Subject: RE: Planning Consultation on BR/57/20/DOC

Engineers Comments Regarding Surface Water Drainage

APPLICATION NO: BR/57/20/DOC

Site Address: 15-17 Kew Gardens Bognor Regis PO21 5RD

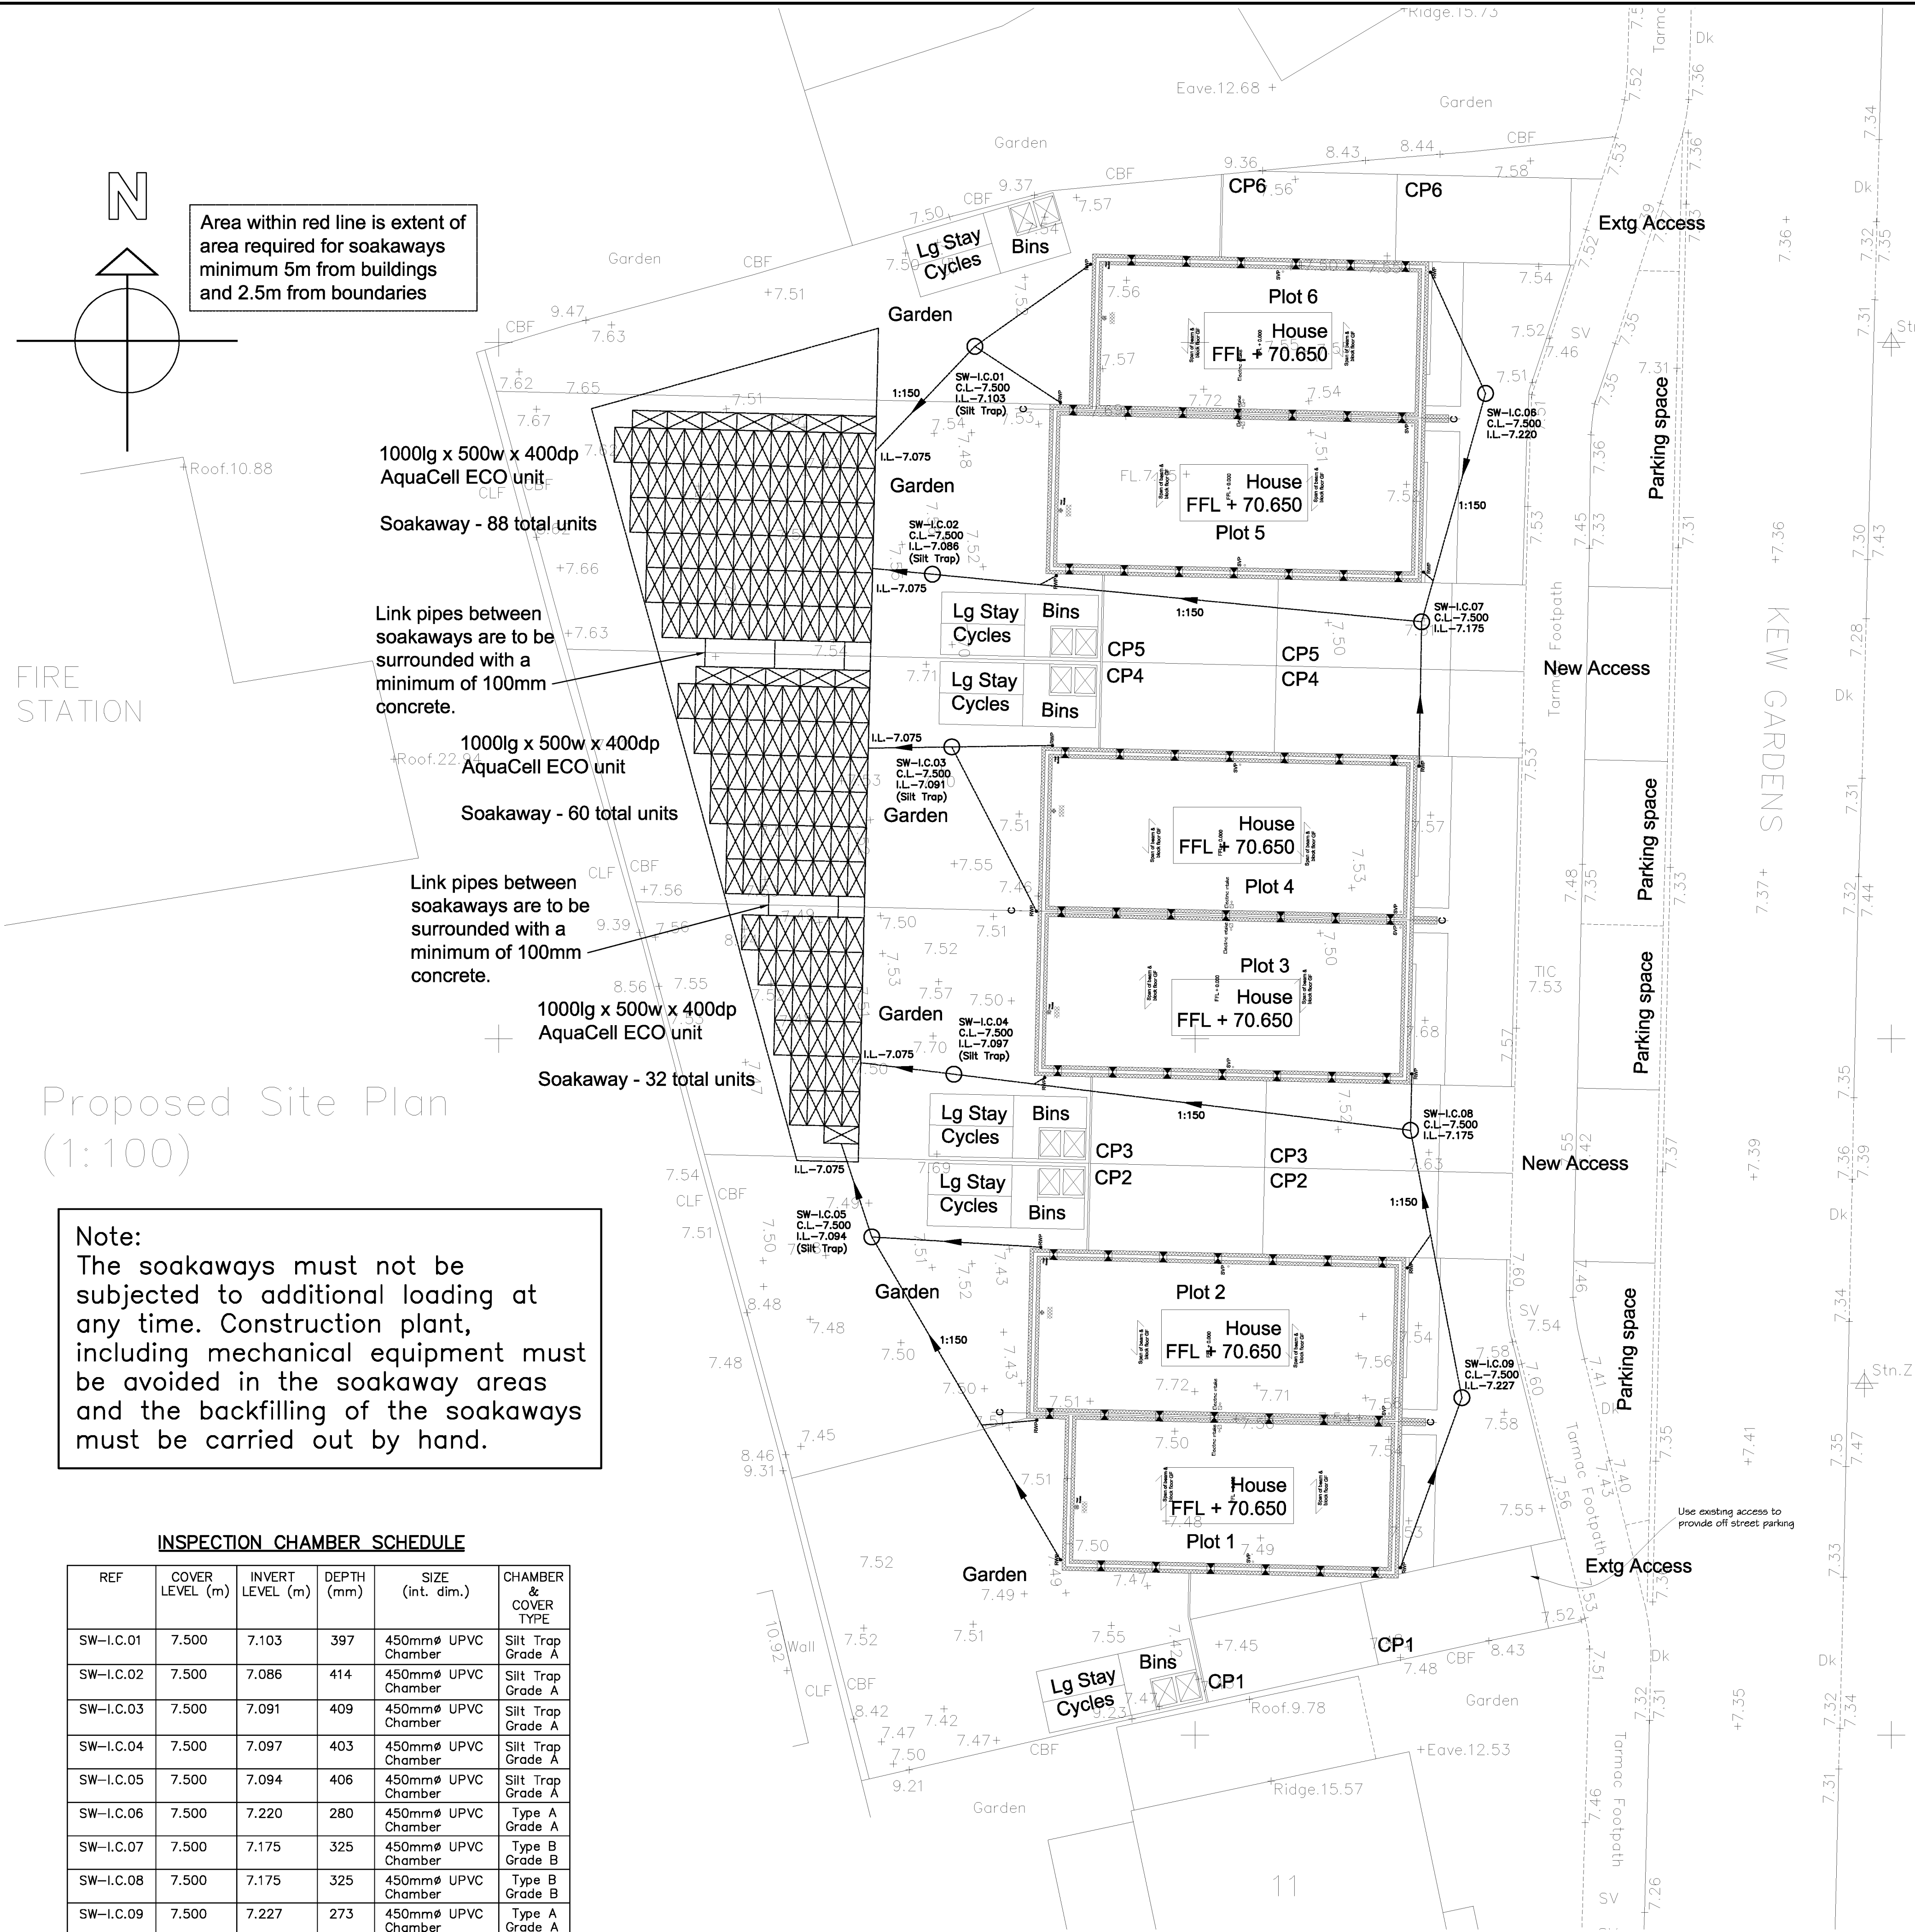
1. Soakaway crates are shown going beneath the boundary fences at plot 2/3 and plot 5/6. The design needs to be modified so that no crates are under boundary fences.

2. The link pipes between the soakaways need to be surrounded in concrete and it is strongly advised that the applicant includes an inspection chamber on at least one of these pipes (please label this manhole/inspection chamber with invert and cover levels and cover type).

3. Please label all pipes with the diameters, pipe materials, surround type, falls and/or invert levels. (If the diameters and materials are consistent a note to that effect stating the specification is sufficient).

4. Please label soakaways with their invert levels, cover levels and cover types (not necessary if construction detail is kept on same drawing, in which case "see detail for levels" – only if moved to a separate construction details sheet, see below).

5. All silt traps need to be labelled with their invert levels.
6. Provide construction detail drawings for the silt traps, inspection chamber, permeable paving and the two different pipe bed and surrounds.

7. Please provide a prominent and clear note that the soakaways must not be subjected to additional loading at any time. Trafficking by construction plant on site, including mechanical equipment, must be avoided. This includes when backfilling the soakaways themselves.
